OXFORDSHIRE COUNTY COUNCIL'S RESPONSE TO CONSULTATION ON THE FOLLOWING DEVELOPMENT PROPOSAL

Application no: 15/01105/REM

Proposal: Reserved Matters to 15/00309/OUT - Proposed new research buildings.

Location: Begbroke Science Park Begbroke Hill Begbroke Kidlington Oxfordshire OX5 1PF

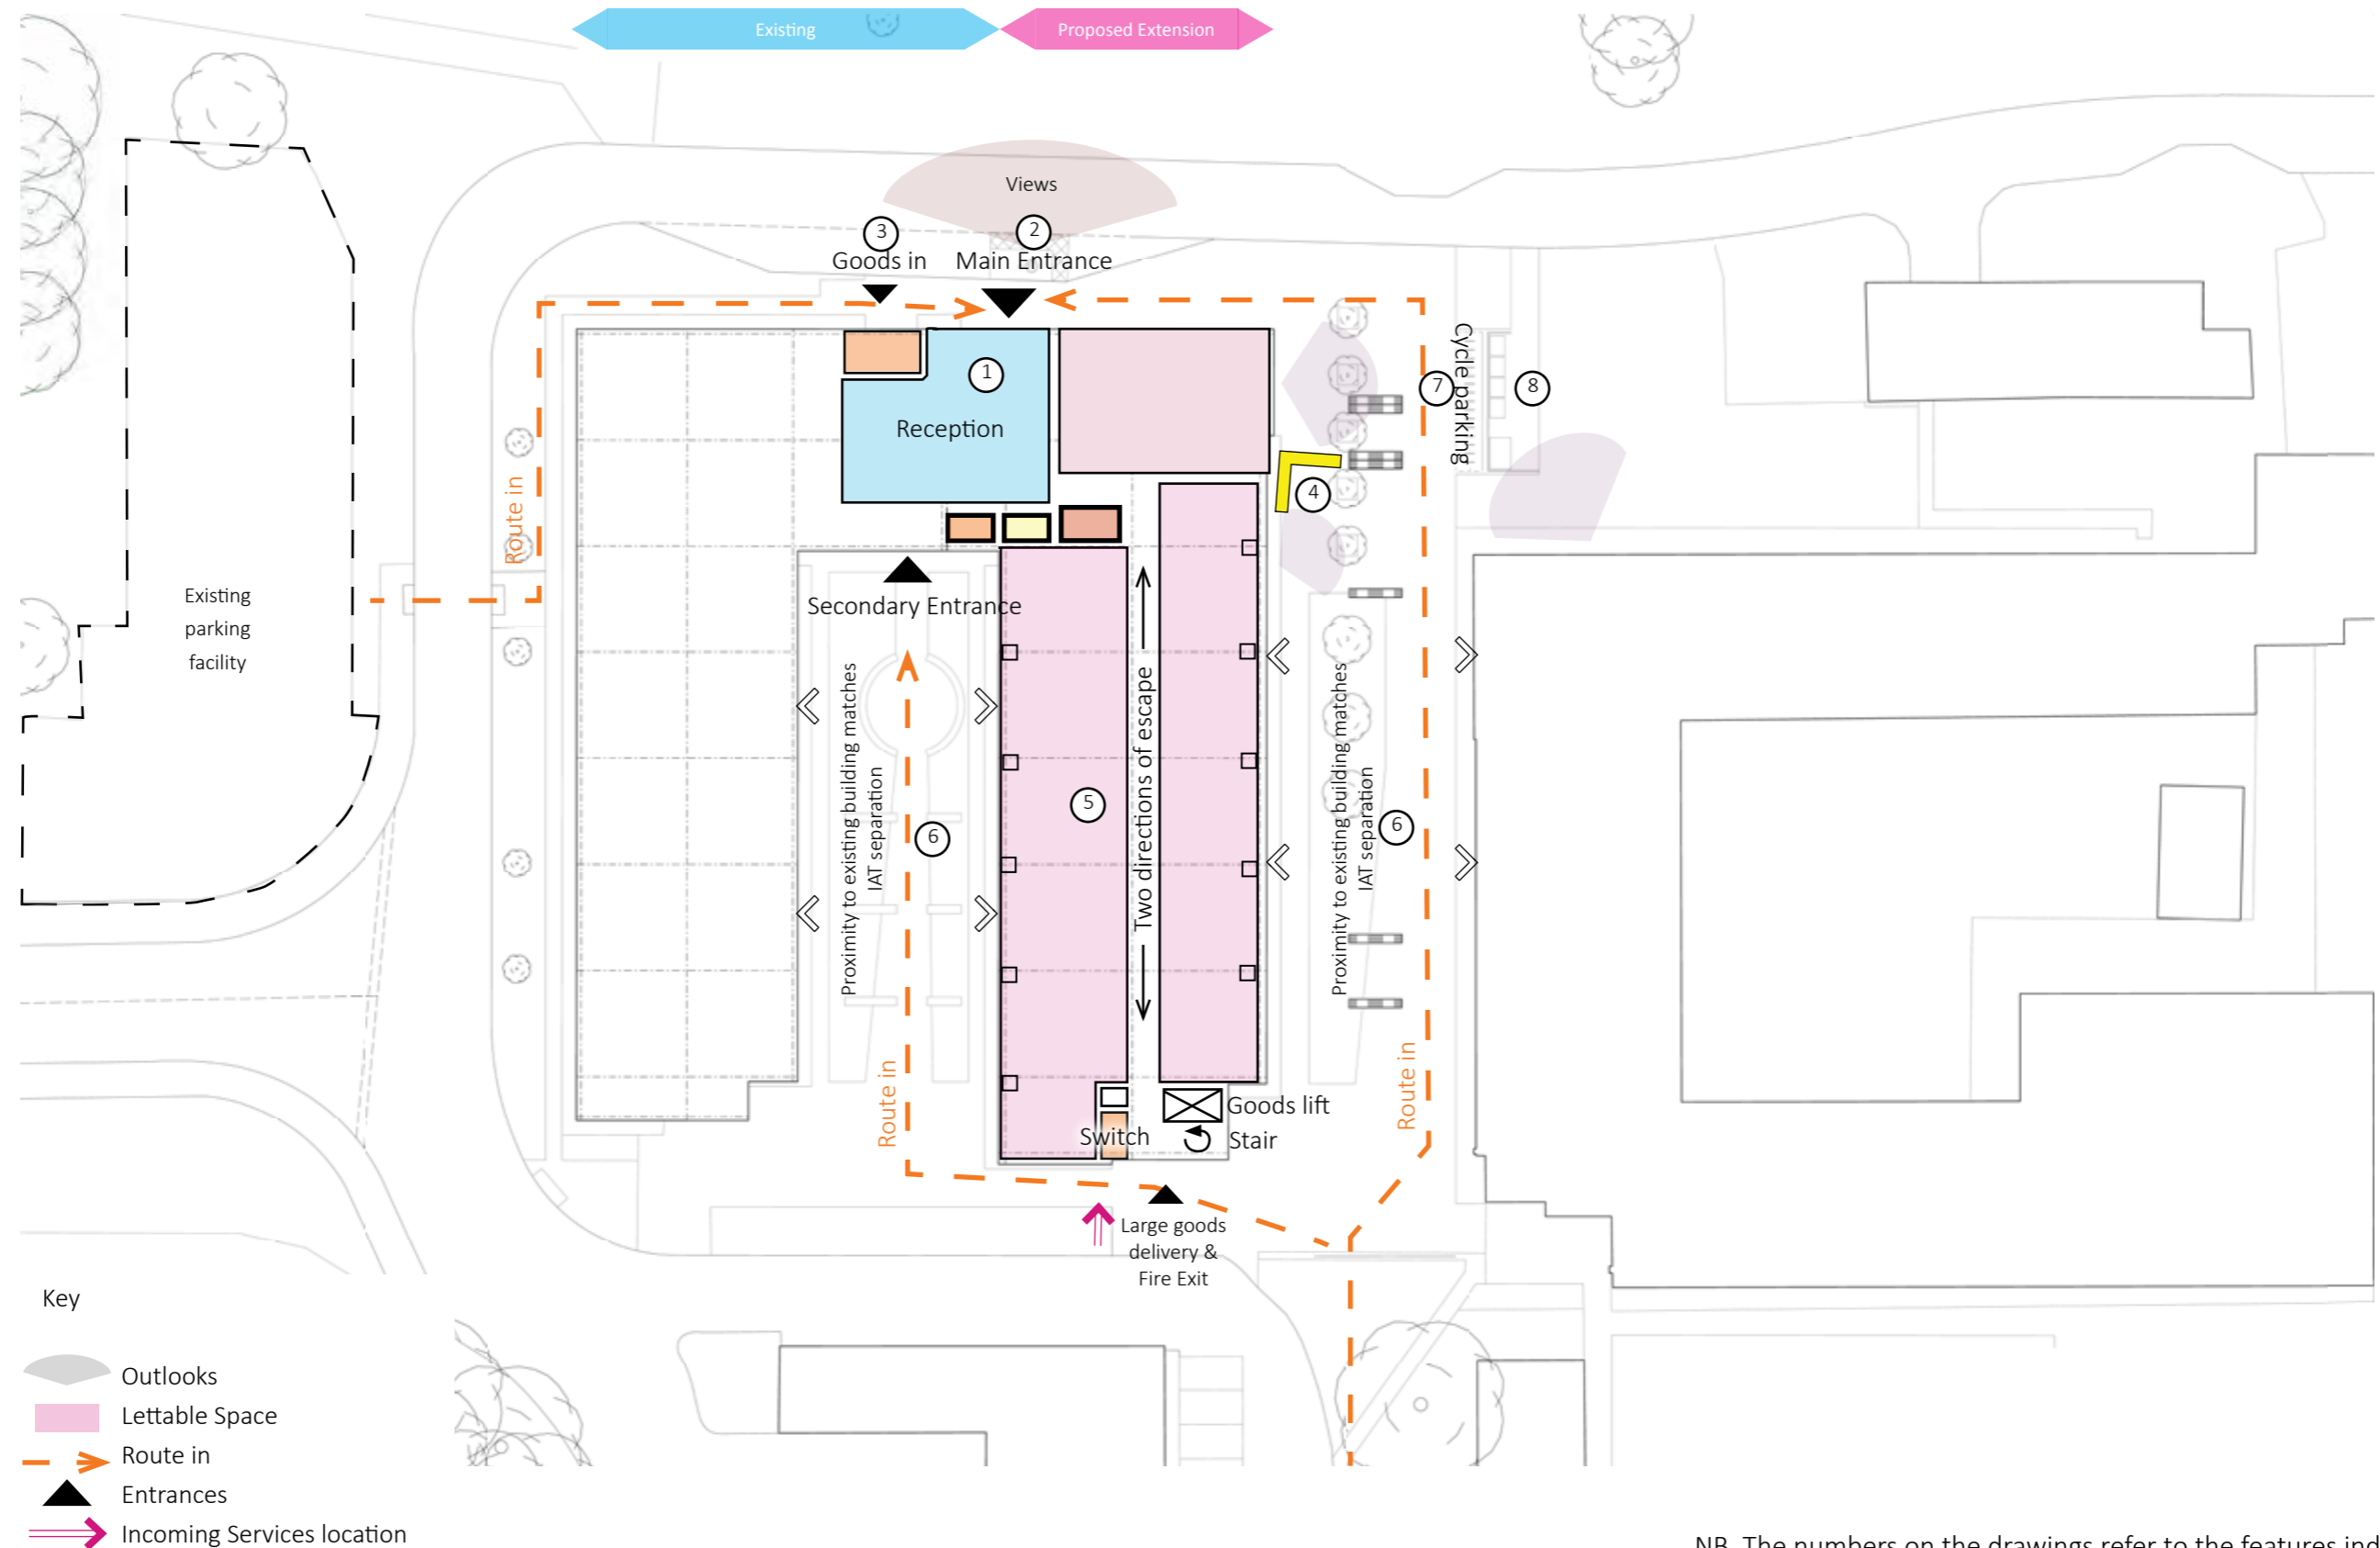
Cycle parking stands have been included in the site layout – this provision is assumed to be additional and is welcomed. However, it would be preferable to provide it nearer to the main entrance to reception.
